Please upload as consultation for BR/49/20/DOC

I have a DOC for Culver Cottage for the materials for the side extension.

Wall finish cedar cladding: Cedar can be left untreated but it also takes paints and stains extremely well. It is also an excellent material for thermal insulation – in summer keeping the building cool and in winter preventing the heat from escaping.

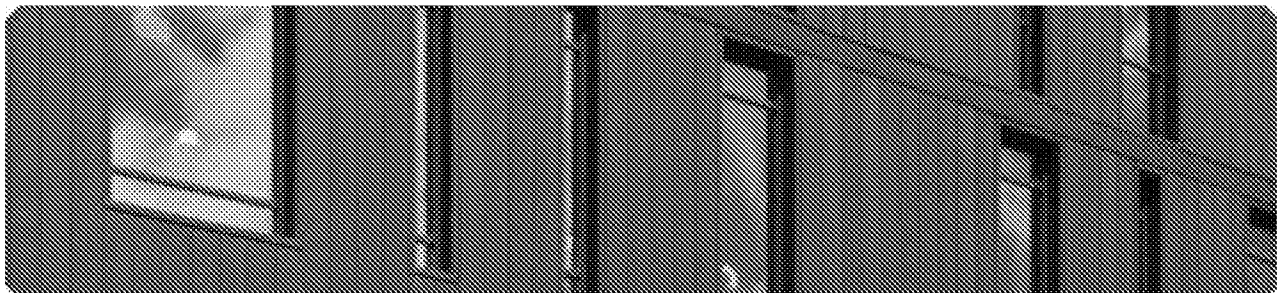
Cedar: I note in the materials schedule that it states 'Cedar can be left untreated but it also takes paints and stains extremely well. However, it is not particularly clear how the applicant intends of treating the cedar – should this be confirmed?
